SPR EA1N and EA2 PROJECTS

DEADLINE 2 - COMMENTS ON STATEMENTS OF COMMON GROUND WITH NGET, NGESO, NGV

Interested Party: SASES

PINS Refs: 20024106 & 20024110

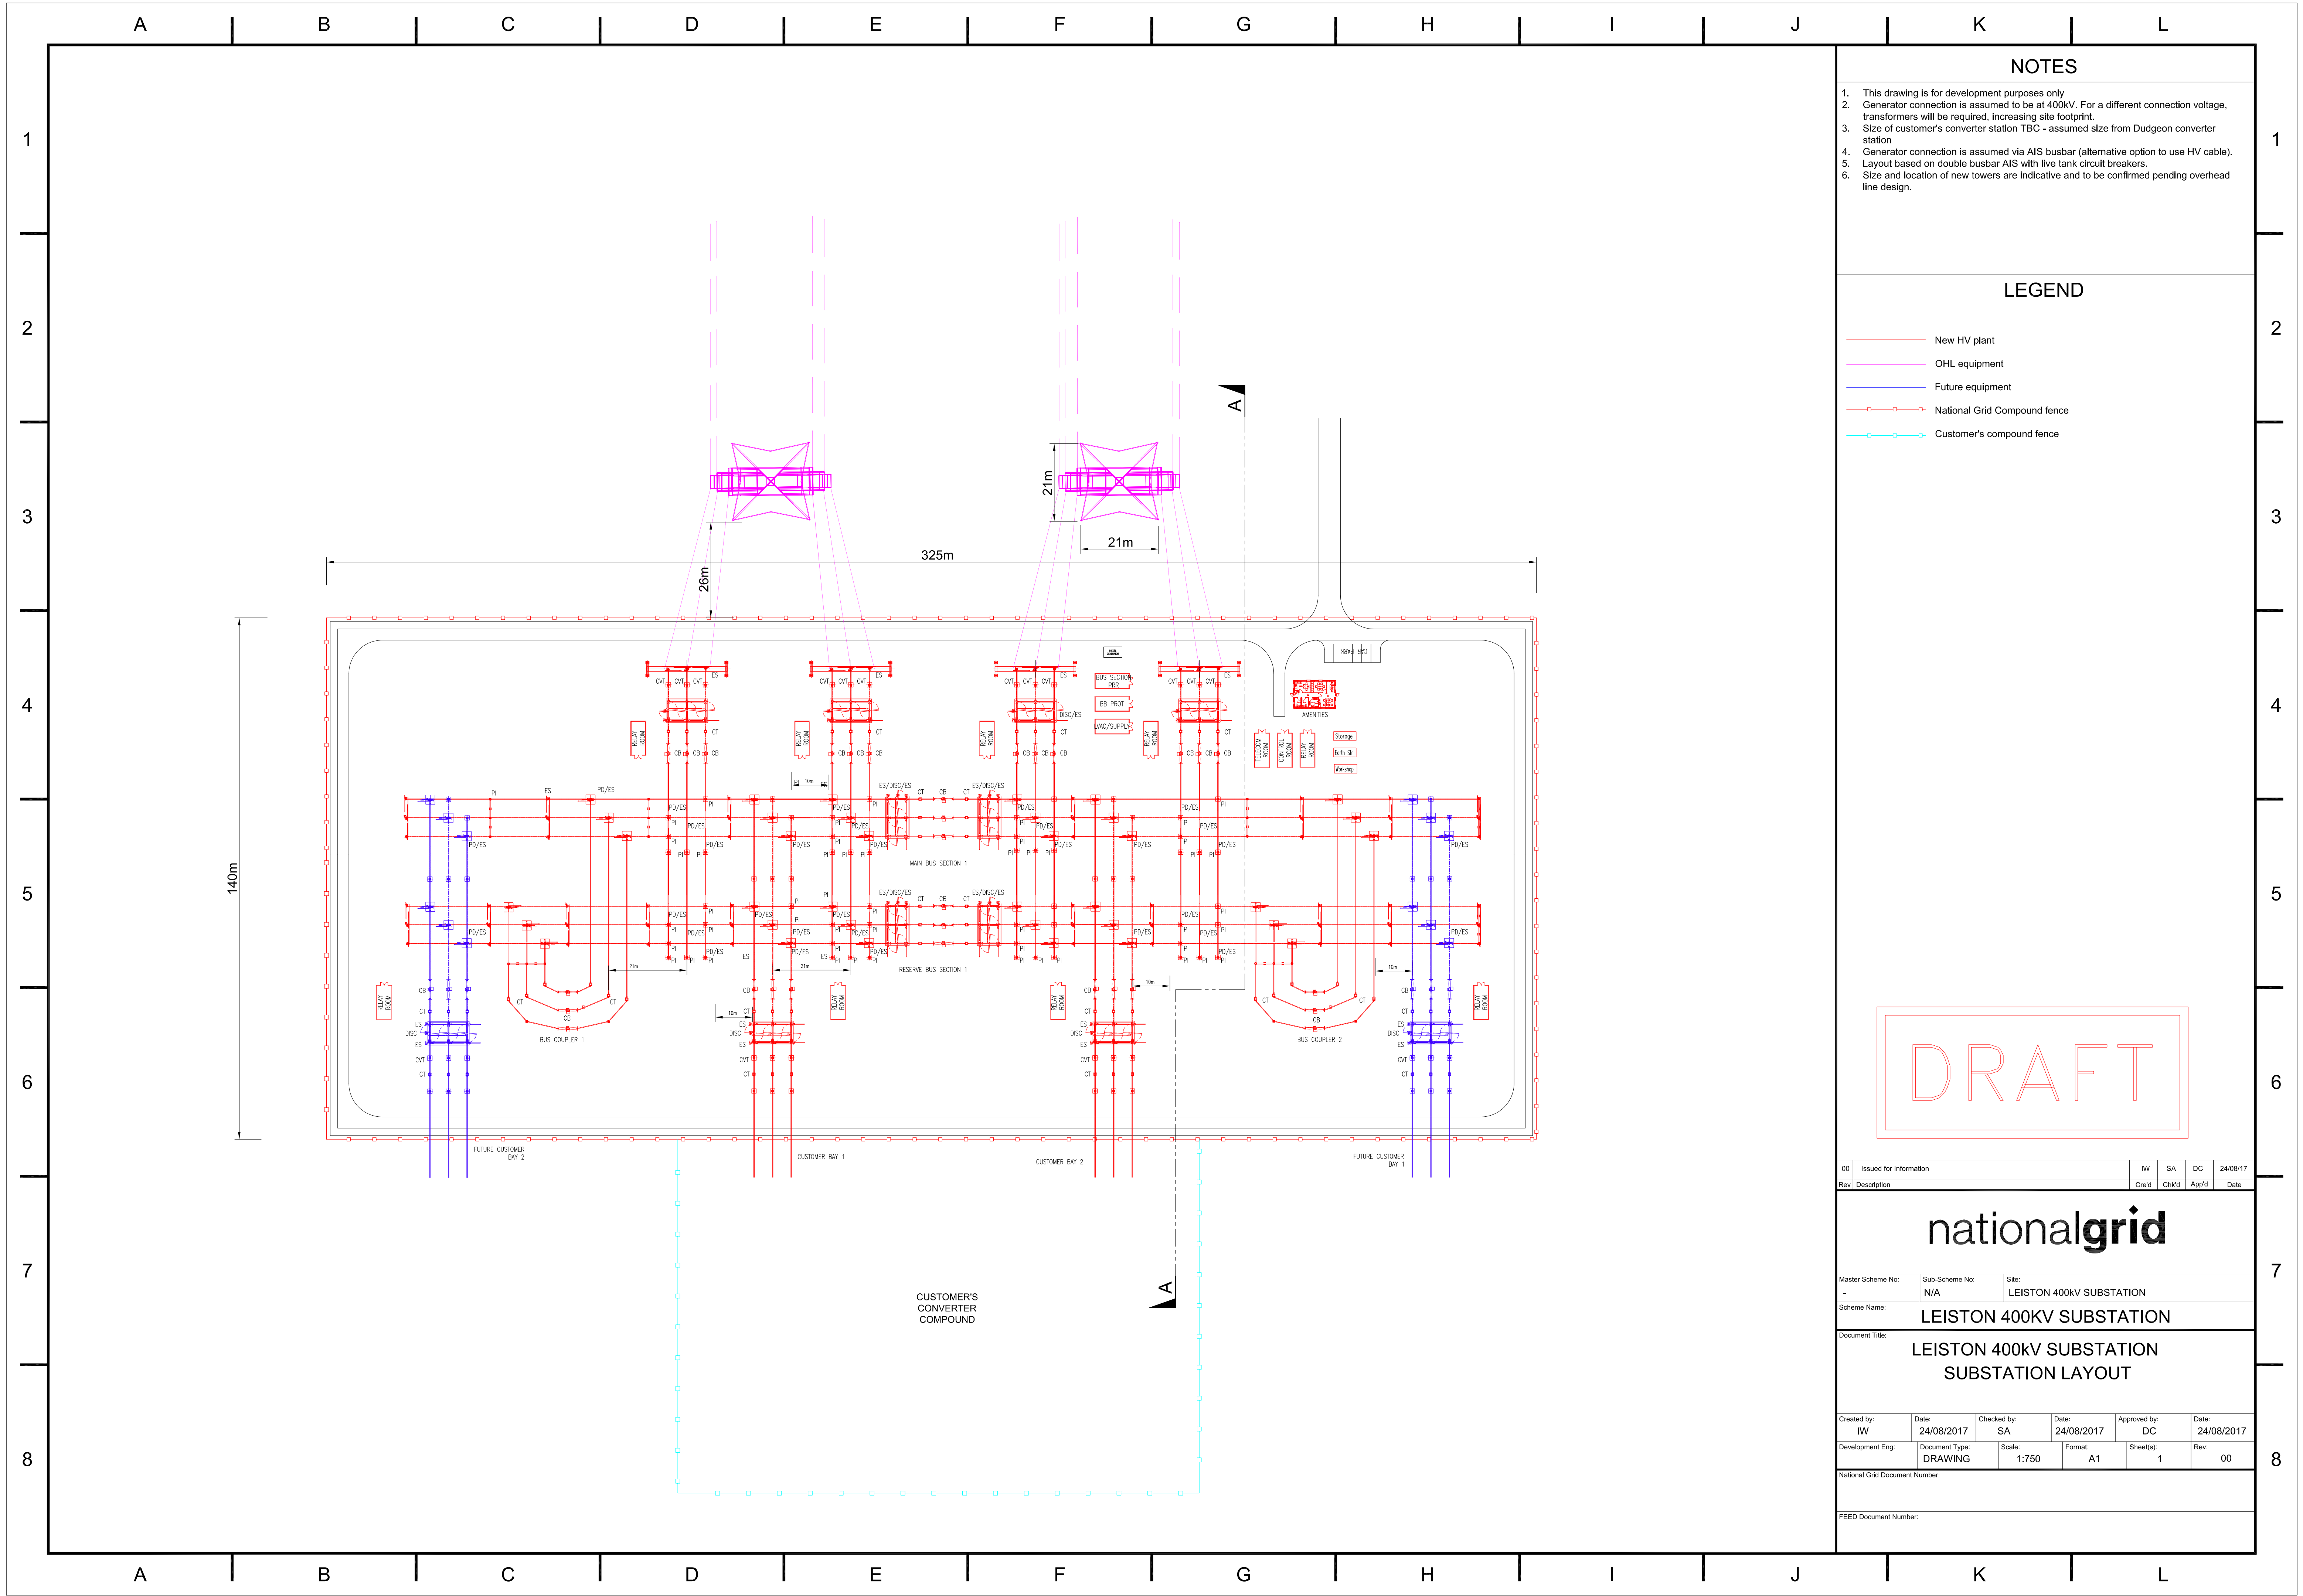
Reference	Statement	SASES Comment
ESO-004 (Ref.1 p6) NGET-004 (Ref. 2 p7) Site Selection and Assessment of Alternatives	SPR & NGET Co-location of the National Grid infrastructure with the onshore substations supports NG-ESO's obligations under Section 9 of the Electricity Act 1989 to develop and maintain an economical and efficient network. These obligations are recognised within paragraph 2.3.5 of National Policy Statement for Electricity Networks Infrastructure (EN-5).	<p>The ExAs are asked to note that co-location is <u>not</u> agreed as NECESSARY condition of meeting EA 1989 requirements. It follows that SPR's RAG assessment was wrong to only score sites as GREEN where they were co-located and within 500m of overhead lines. A RAG status of RED for being over 1km from OHLs is not justified or acceptable.</p> <p>Alternative SPR sites within (at a minimum) a 5km radius of the preferred NGET substation site should have been assessed.</p> <p>As a general comment SPR's site assessment methodology fails to distinguish between the Engineering requirements of the NGET substation, and the SPR substations. As a result the assessments reached should not be relied on. The NGET substation is probably best positioned close to OHLs whilst the SPR substations can be up to 5km away from the NGET connection (and more in some cases c.f. IFA2 Interconnector project at about 10km). The RAG criteria do not reflect this.</p>
